## MMC D Street sidewalk construction

Jennifer Ladd <jwl@portlandmaine.gov>

Wed, May 22, 2019 at 9:51 AM

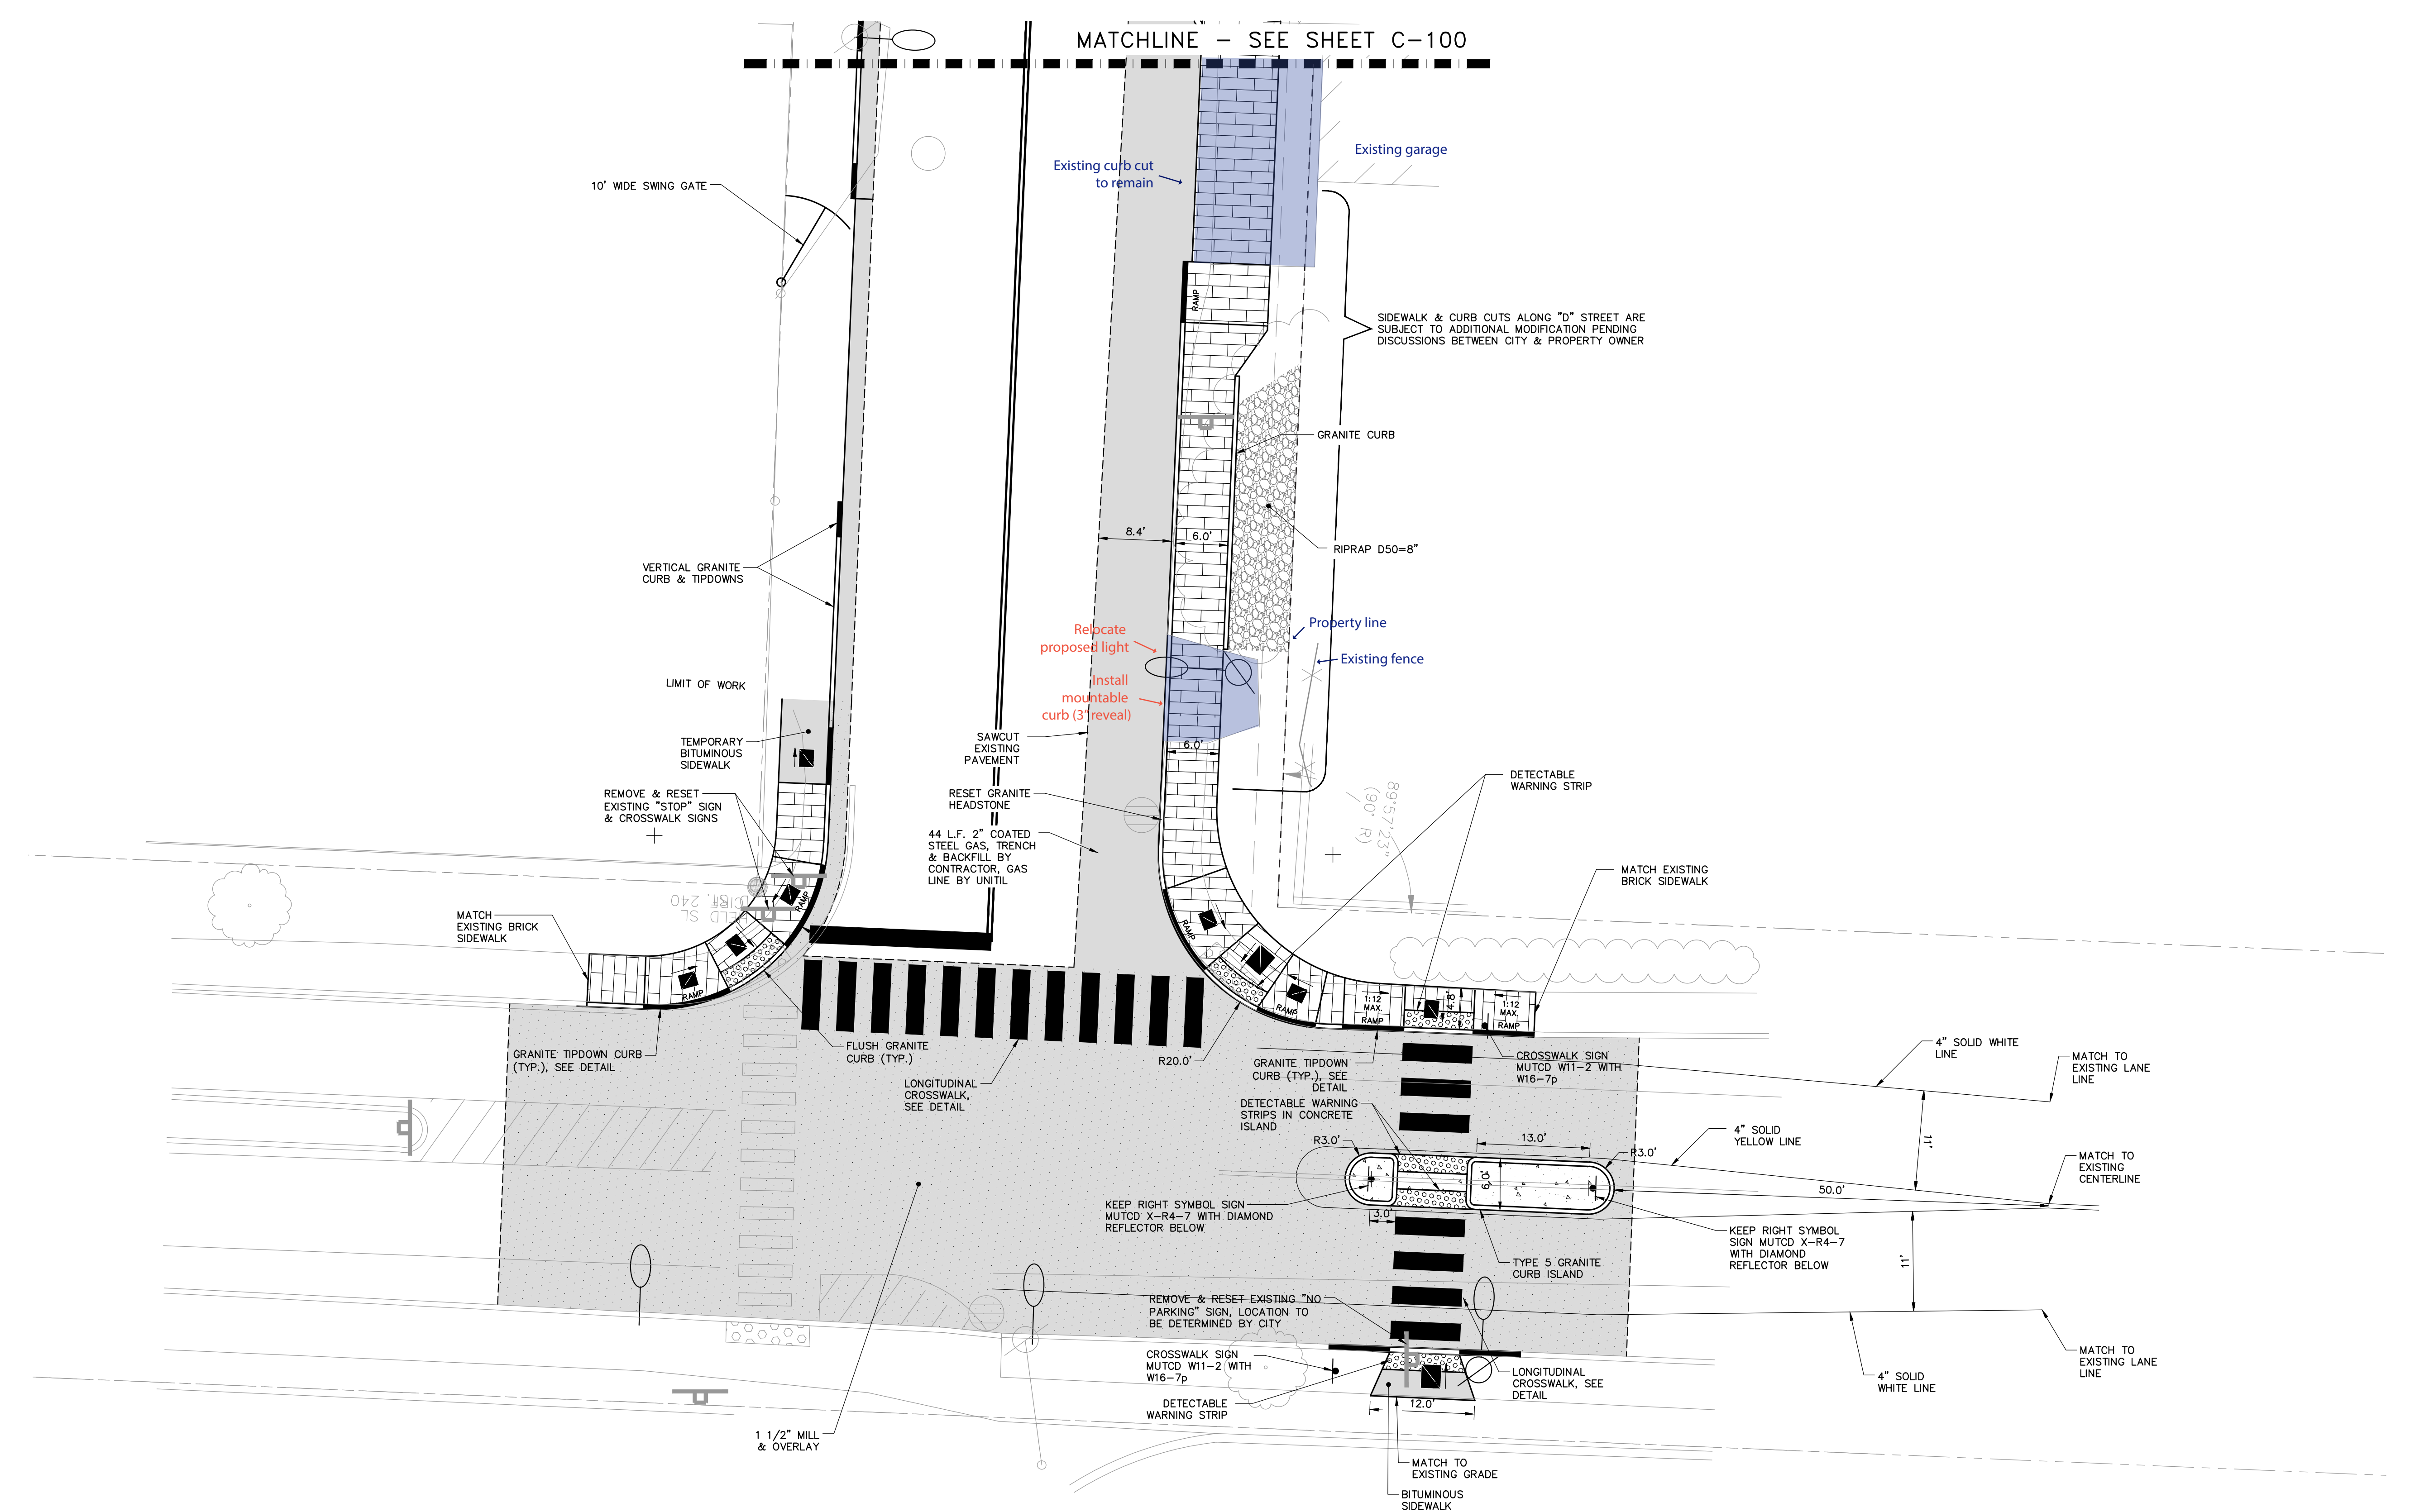
Quick question about the mountable curb & driveway: it looks like the spot grades given indicate the 'tipdowns' aren't really tipping down at all. They show 3" of reveal on each side. Is this right or are they meant to reduce curb reveal from something greater than 3" down to the 3" specified for the mountable curb?
